Re: Objection to MP08_0244 MOD 1 Modification Request for Mixed Used Development at 23-37 Lindfield Avenue and 11 Havilah Lane, Lindfield

1 SHADOW DIAGRAM - 21stDEC_9AM
5003 SCALE1 : 650

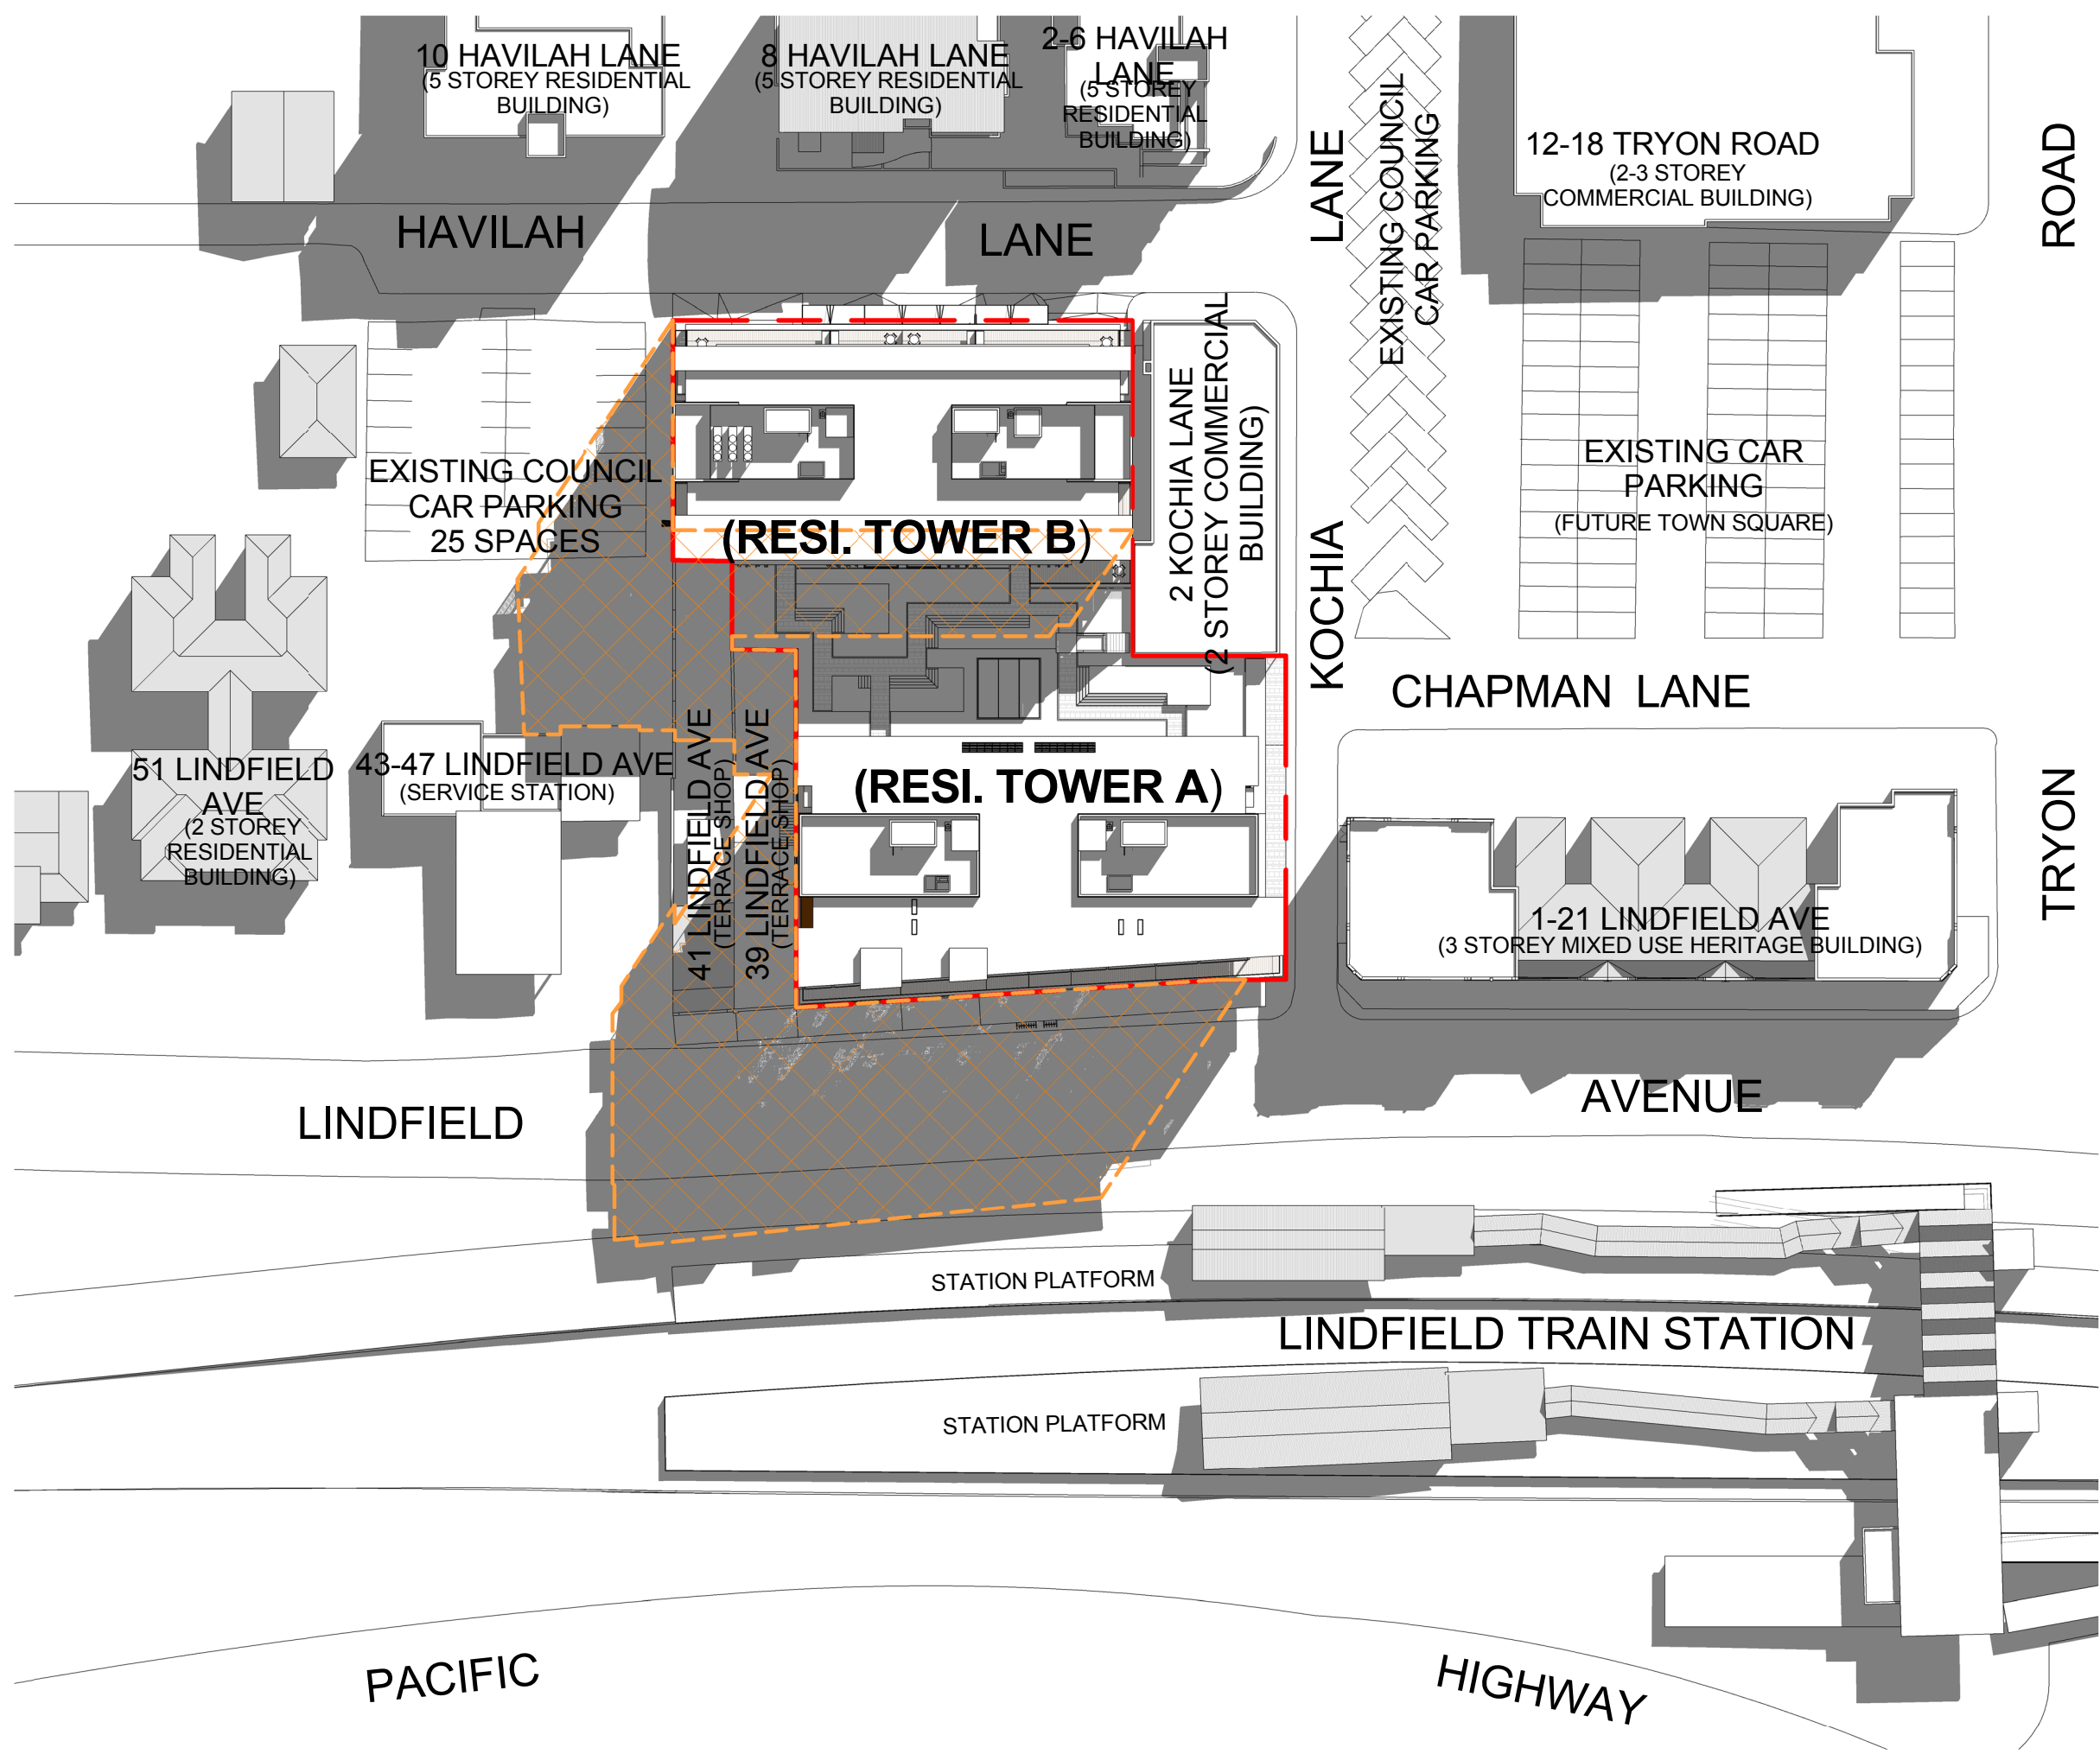
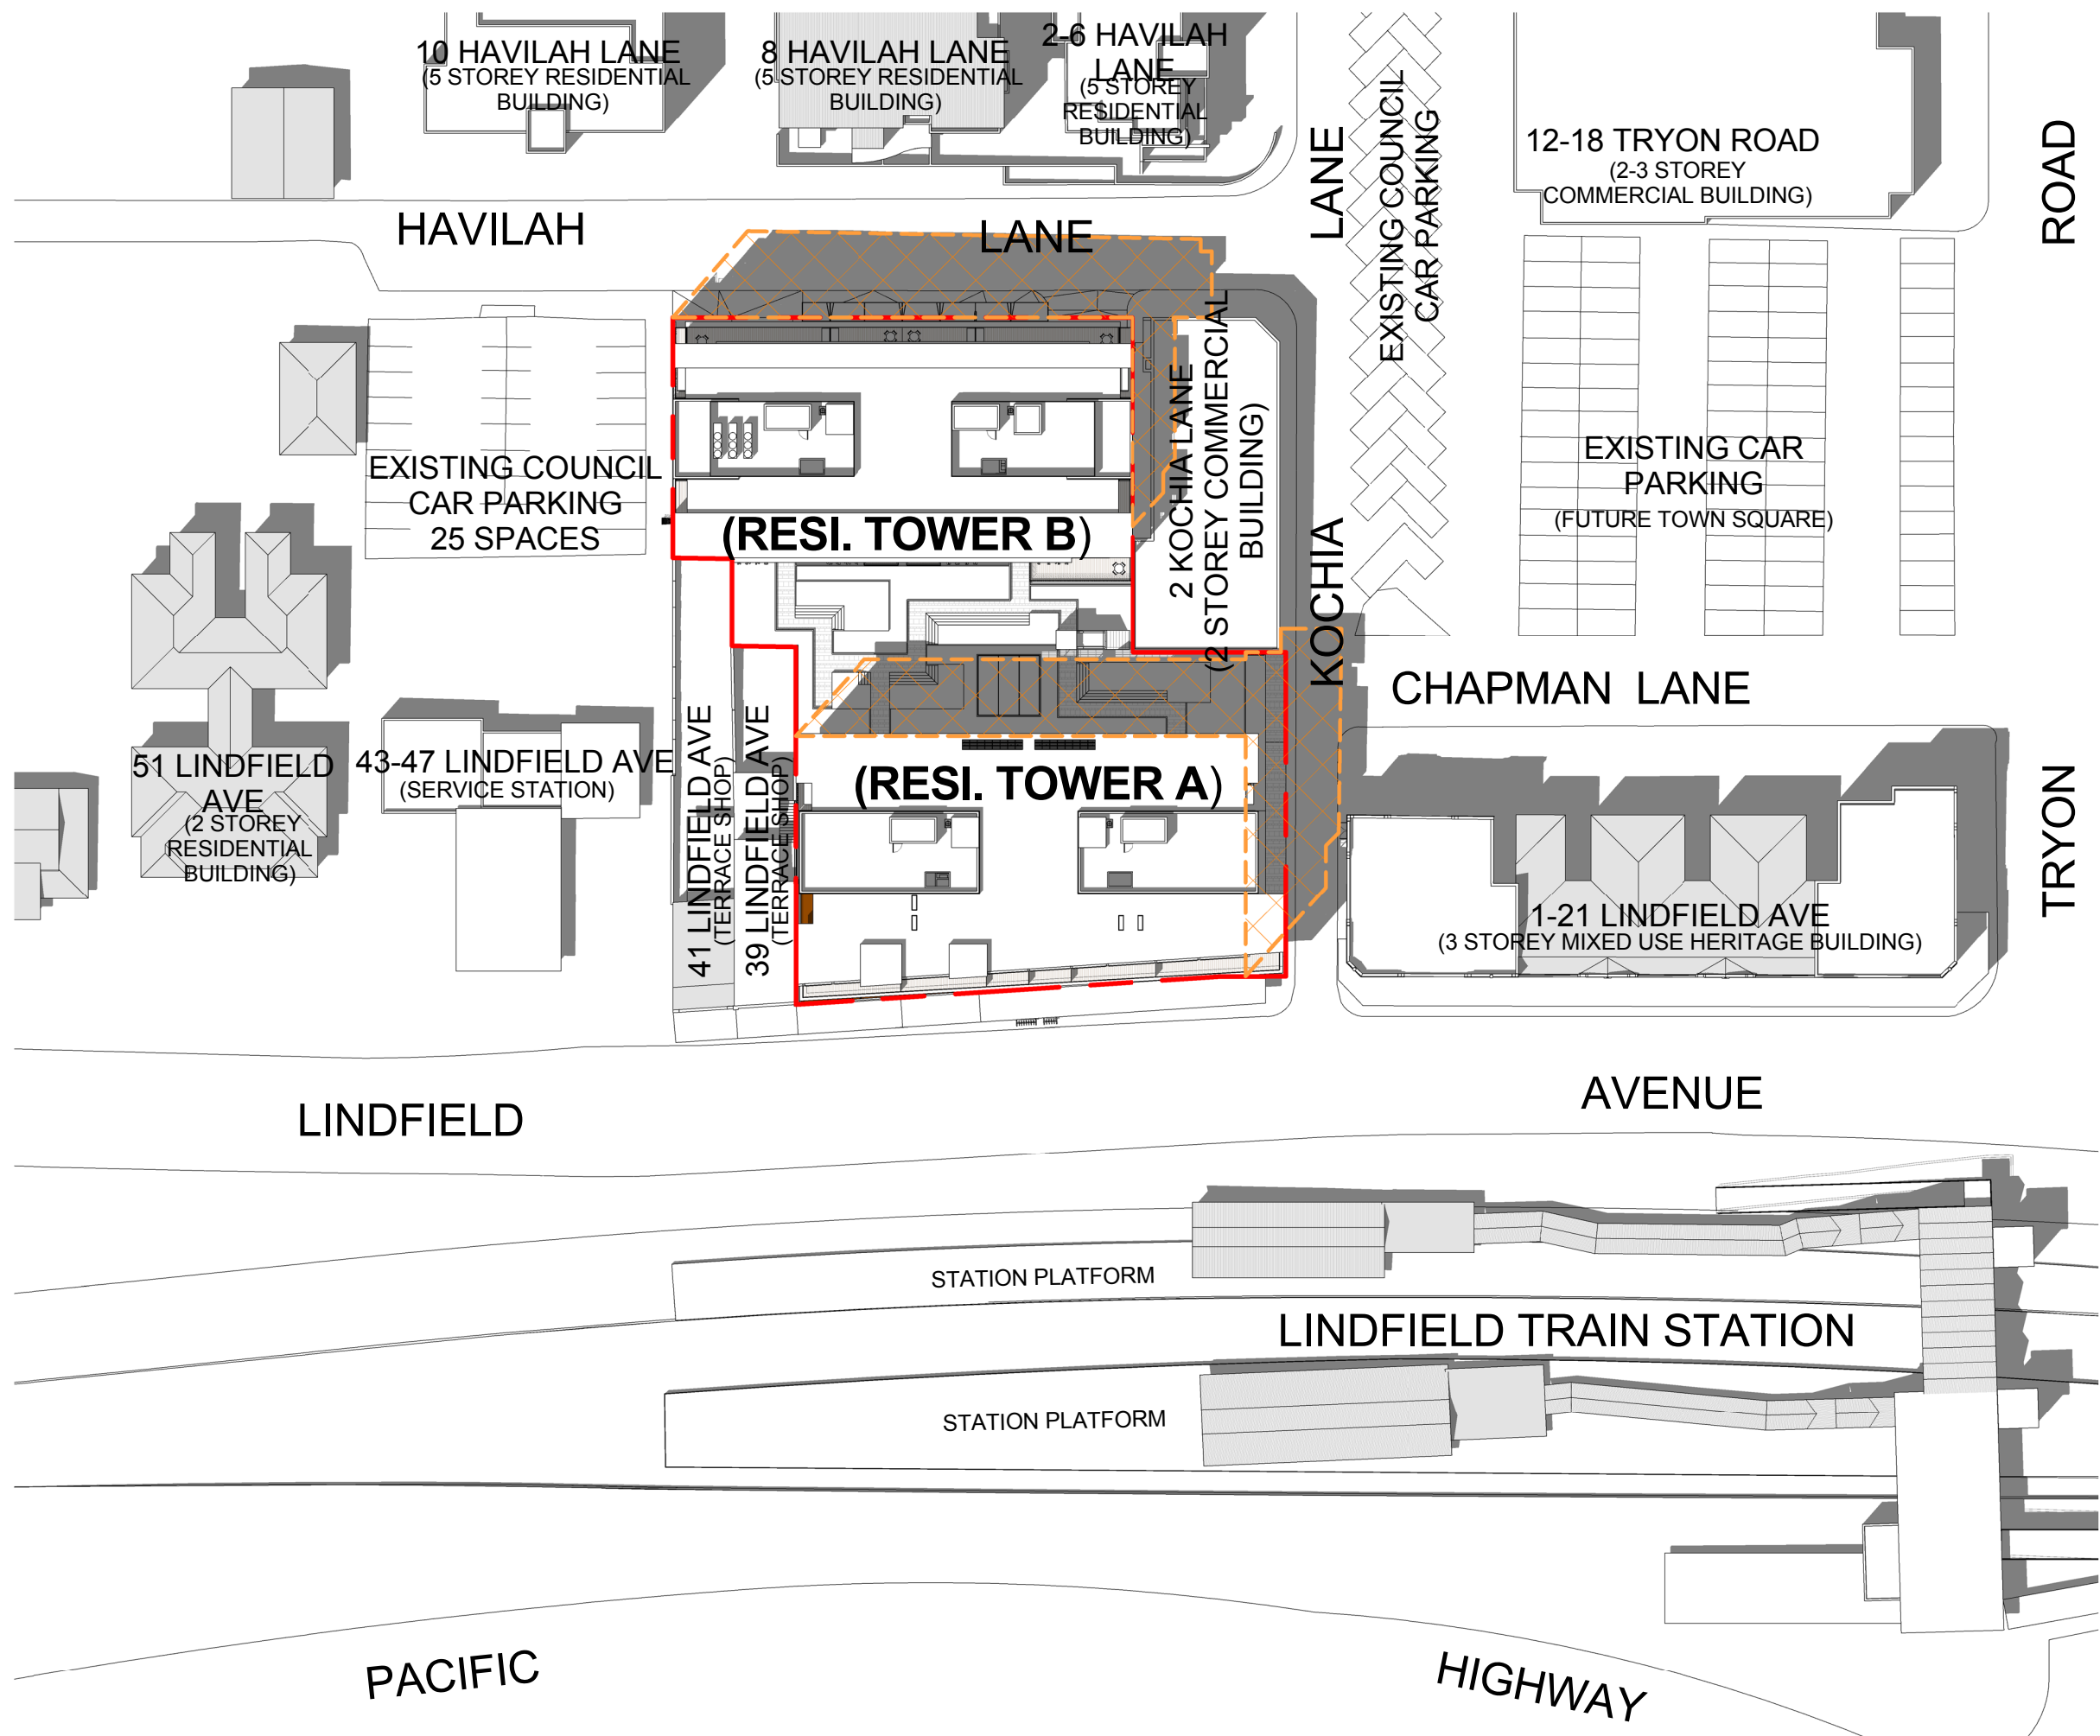
- The additional storeys create new adverse shadowing: a) for residents in the Havilah Lane apartments, particularly after 3pm b) for the popular outdoor café and central Lindfield hub area at 12 Tryon Road in afternoons, particularly in winter and c) for all commuters on the city bound Lindfield rail platform, instead of 50% of the year as approved, it will now be in shadow in the mornings 75% of the year
